From: Laura Gibbons
Sent: 12 July 2018 09:10
To: Planning.Responses
Subject: RE: Please find attached amendment on planning application Ref: A/31/18/OUT

Engineers Comments Relating to Surface Water Drainage

APPLICATION **A/31/18/OUT**
NO:

Description of Works: Outline application with all matters reserved for the erection of
2 No. 3 bedroom semi-detached properties & associated

Client
Chesterman Homes
Drawing Title
Surface Water Drainage

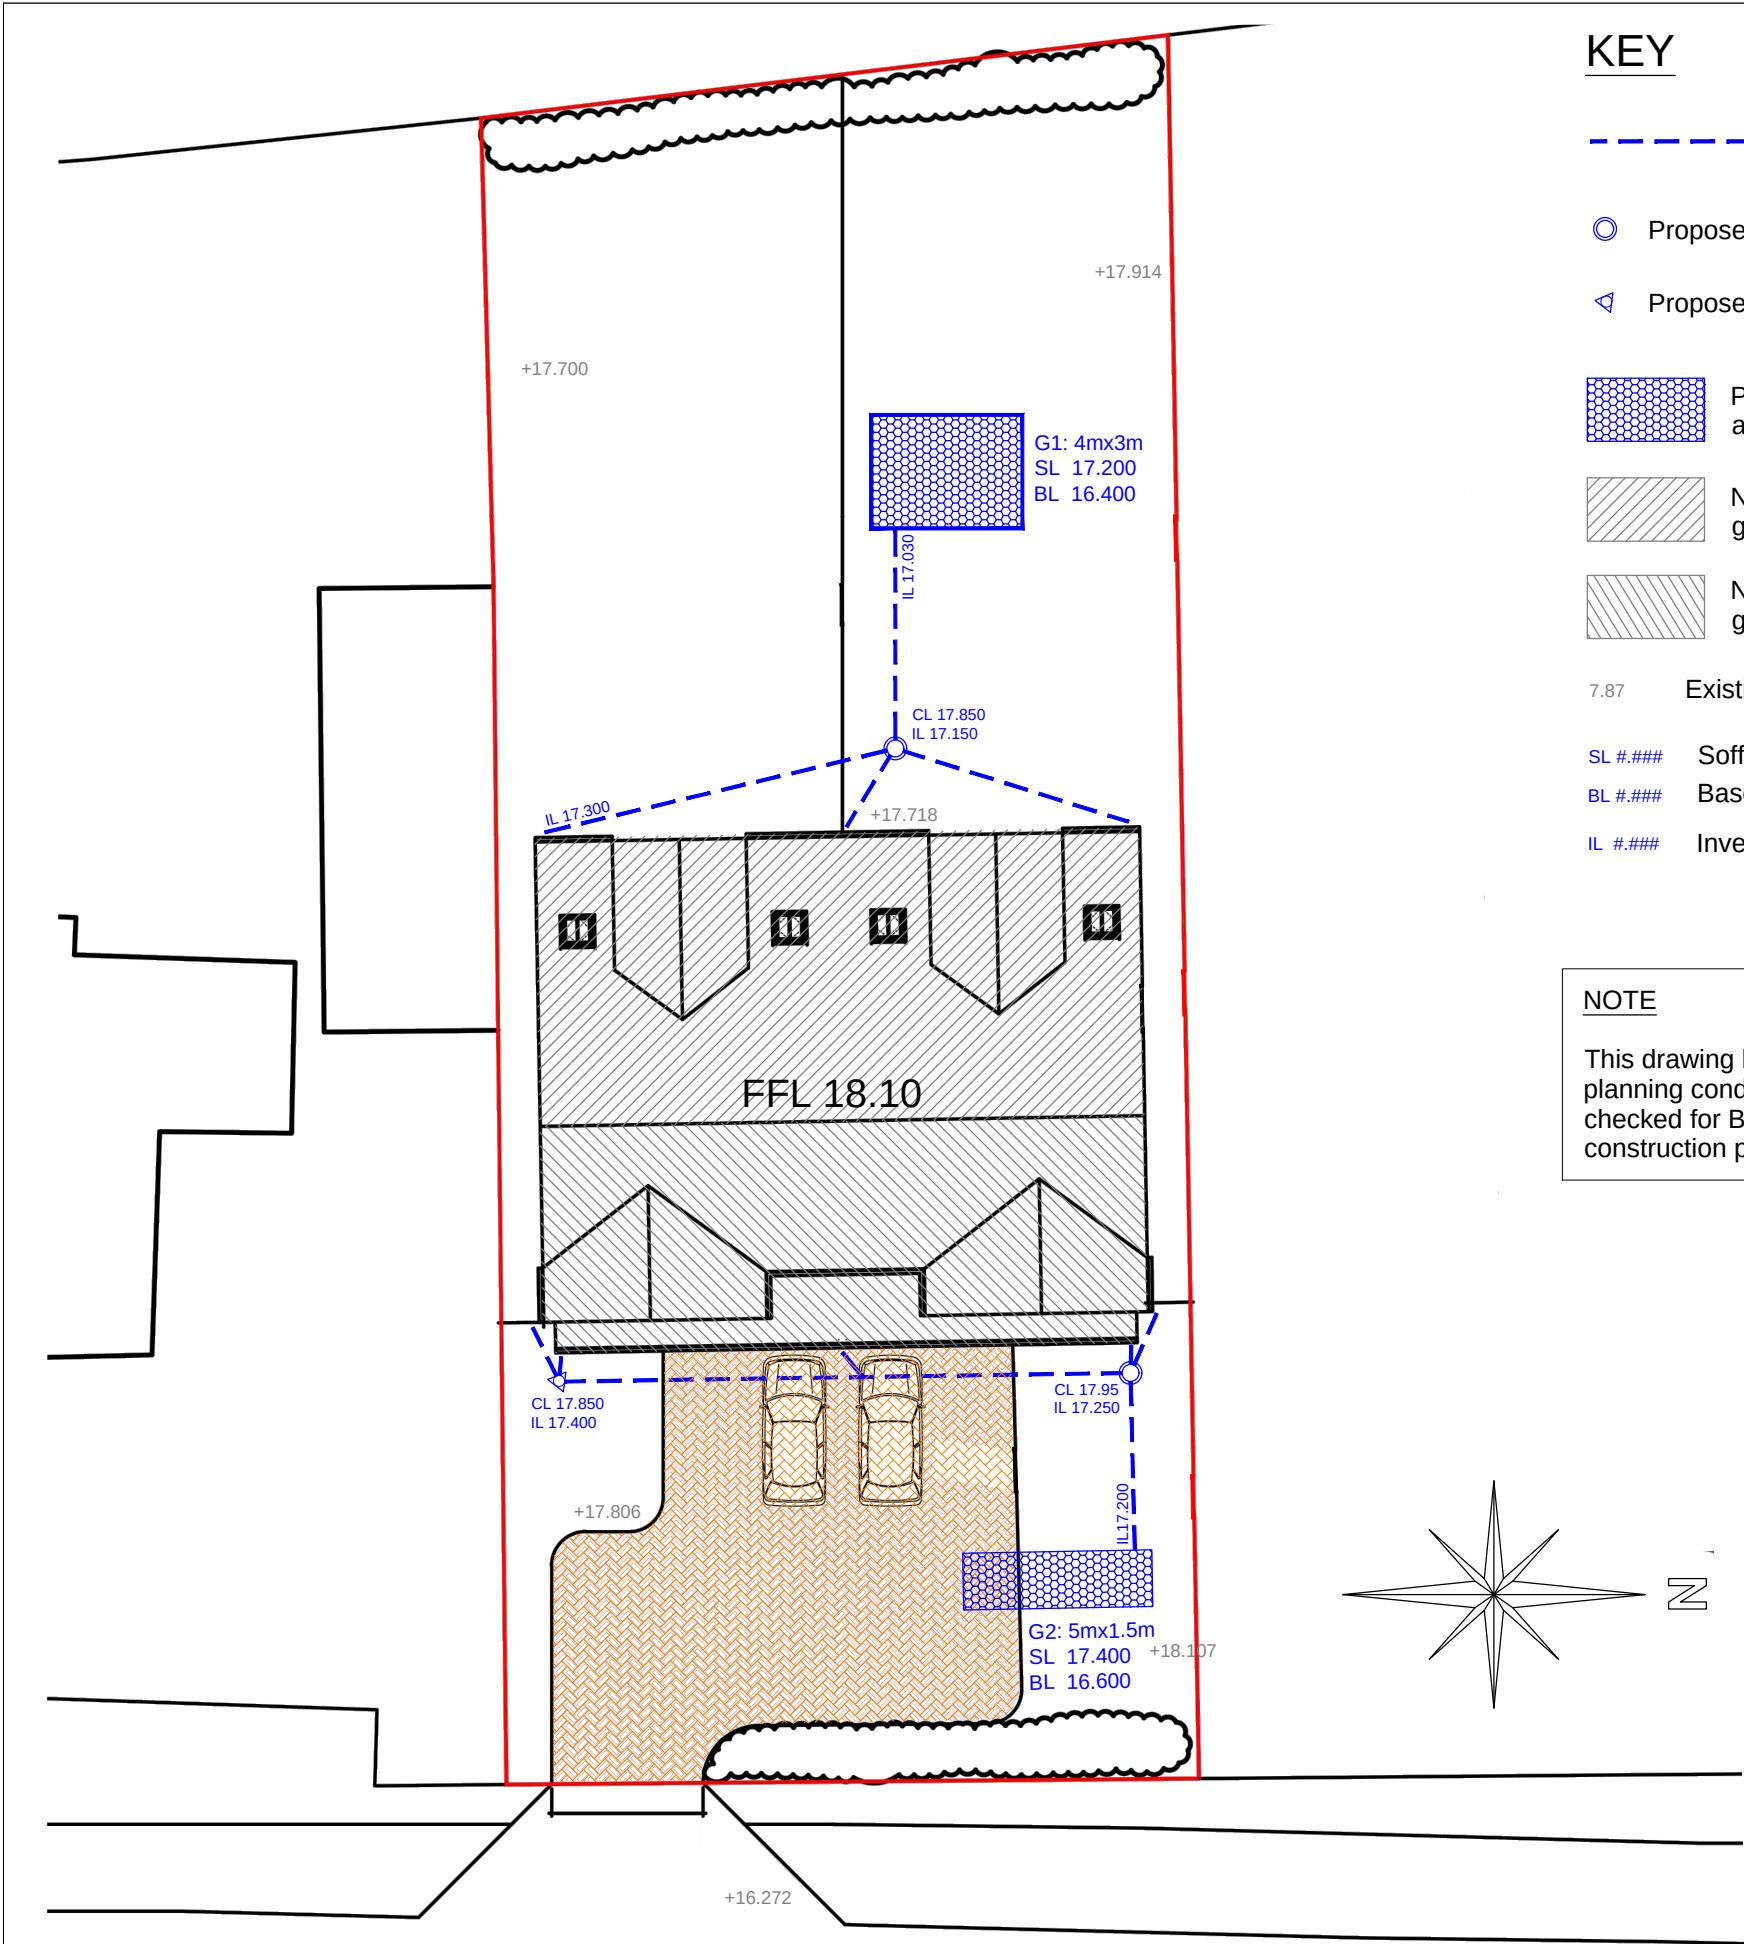
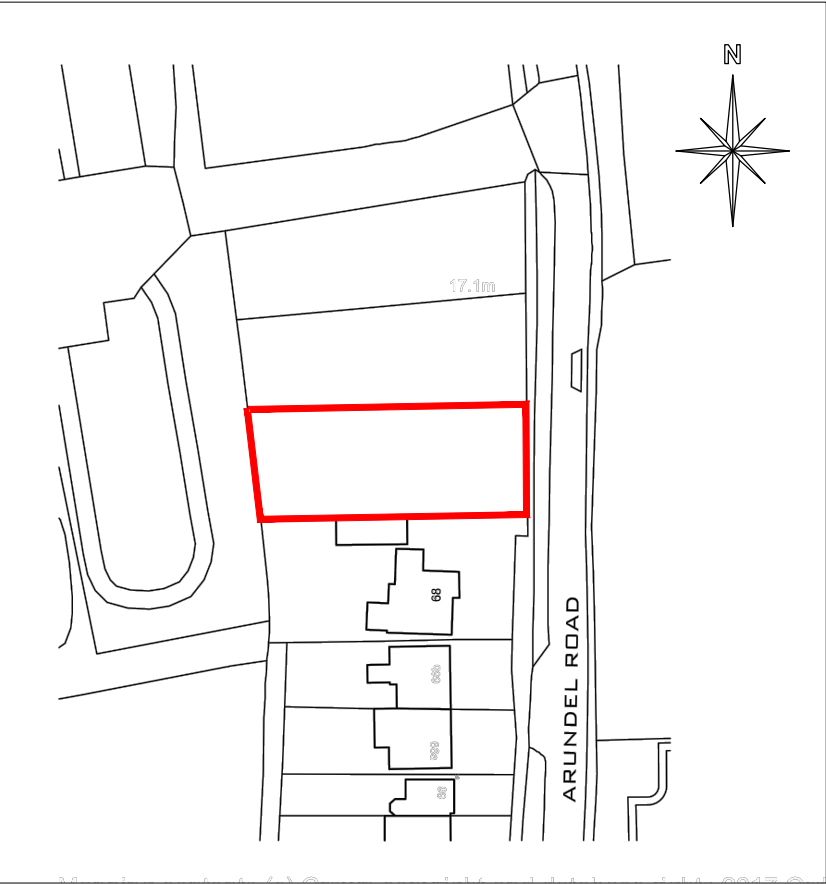
It is unclear if there are any proposed alterations to the agreed drainage layout. Please can the applicant confirm there are no changes or ENGD2B should be applied.
